REASON FOR PERMIT: Rebuild porches, walkways & stairs

BUILDING PERMIT REPORT

DATE: 1/20/98 ADDRESS: 12 Gilman St
REASON FOR PERMIT: rebuild porch
BUILDING OWNER: Robert Haines
CONTRACTOR: K+D Carpentry
PERMIT APPLICANT: Robert Haines APPROVAL: *8, *10, *13, *14, *15, *30, *31 **DENIED**
USE GROUP R-2 BOCA 1996 CONSTRUCTION TYPE 5B

Re: Mr. Robert Haines (Stairway request)

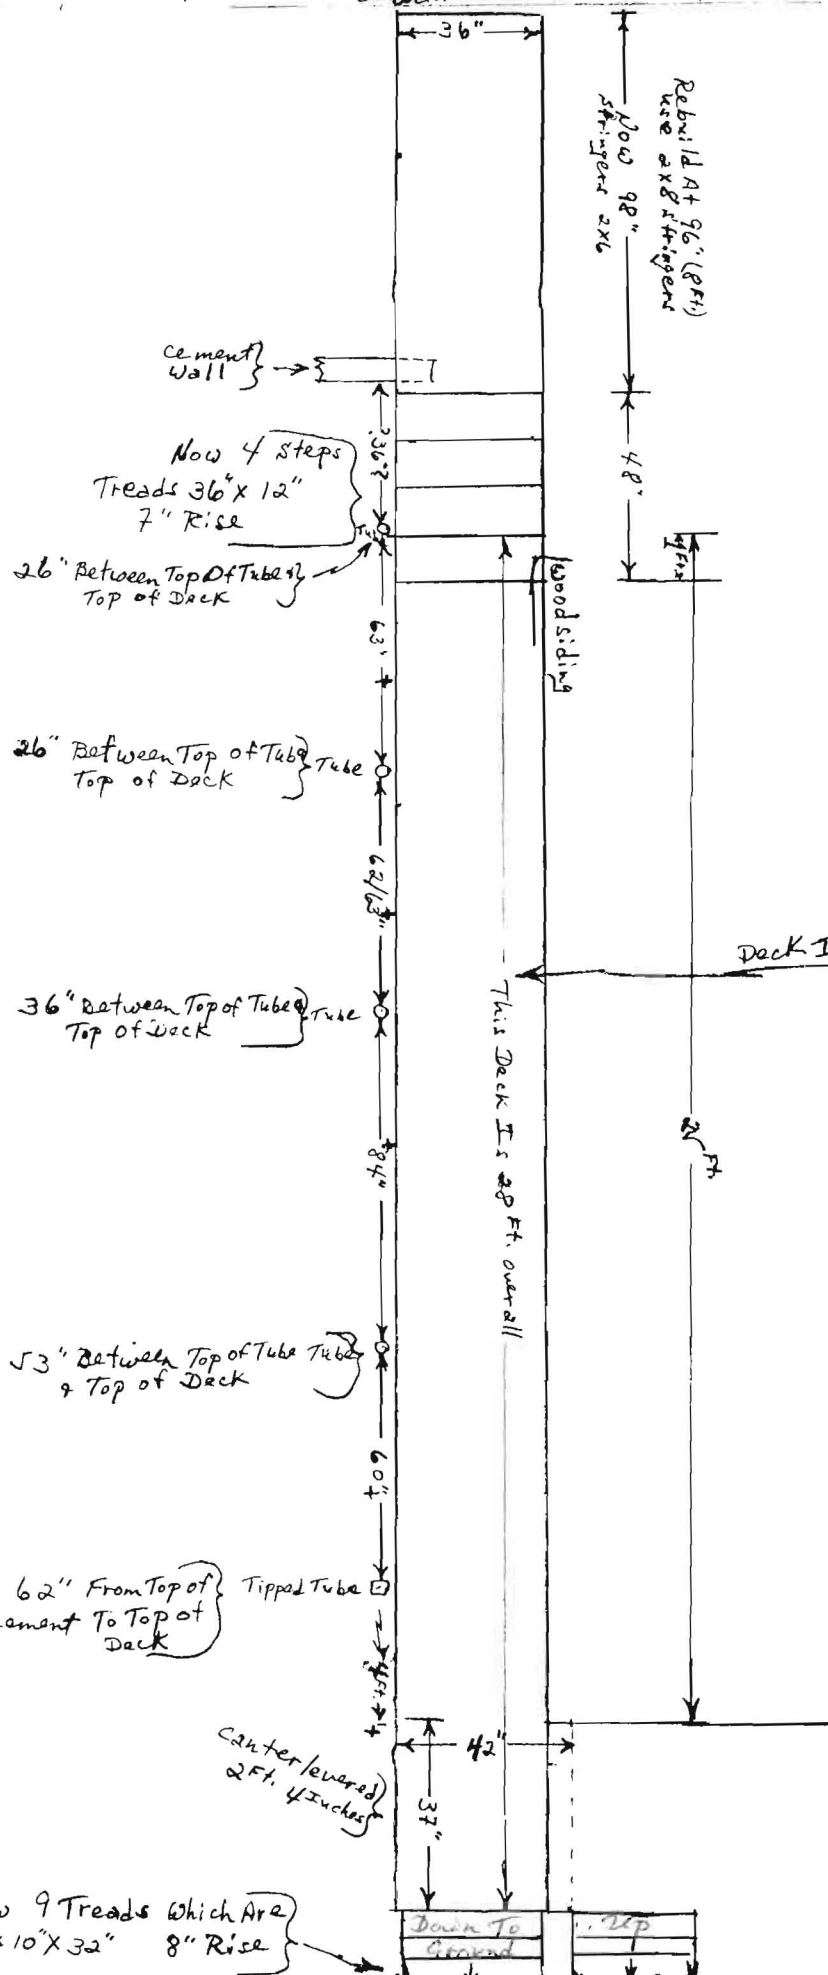
20 Jan 98 - This permit was issued after the fact - This was a replacement therefore some code requirement could not be met. 21/Jan/98 Check stair - Handrail grip too large - openings between stair tread and guard too large.

As you are aware there are two issues that have come to light since the construction began (now nearly completed). Item one) the opening size or space at the bottom of the rails on the stairs. The code [which is a code for new construction] states that no opening may be so large that a four inch sphere can pass through that opening. The laws of physics and geometry do not allow, on older rehabilitation, for a maximum four-inch opening. Most older stair tread/rise would leave a five or six inch

Item two) The hand rails: It has been suggested that I request of you a variance to waive the "1 1/4 to 2 inch round graspable hand rail" in favor of continuing to use the 2 X 4 style of rail that previously existed; see BOCA Code S1022.2.4 as to hand rail requirements. As you are aware this is an outside walk, exposed to the weather; be it sunshine, rain or snow. I suspect that this means of egress has existed since the 1920's. The main stairway ends 16 feet in the air and begins approximately 24 feet in the air and hangs - exposed - off the side of the building. I would think the more solid the better.

1. Opening limitations on guards, section 1021.3 of the city's building code.
2. Handrail grip size, section 1022.2.4 of the city's building code.

"The triangular openings formed by the riser, tread and bottom rail at the open side of a stairway shall be of a maximum size such that a sphere 6 inches in diameter cannot pass through the opening". . . I feel that this can be accomplished by dropping the guard. Therefore would not be needed

"All stairway handrails shall have a circular cross section with an outside diameter of at least 1 1/4 inches and not greater than 2 inches".

23-Mar 98 Check area with Lt. McDougal, two areas need railing. Top of run - and first 5 steps. 6 MAY 98 work completed to point of acceptance. (meets intent of code) \$/

opening. It is my understanding from our conversation last evening that if the stair sidewalls (rails) are lowered to within one inch of the outside or projecting point of each tread - it will be acceptable to you, and therefore the City.

A couple of suggestions have been made to resolve the hand rail issue. One is to drop the plywood one inch below the top 2 X 4. The second is to mitre the 2 X 4 and plywood at a 45 degree angle by approximately 3/4's of an inch on each of the top sides. This would be my preference.

Request #1 I feel will meet the intent of the code.

Request #2 I feel that Mr. Haines can meet this requirement and should meet this requirement.
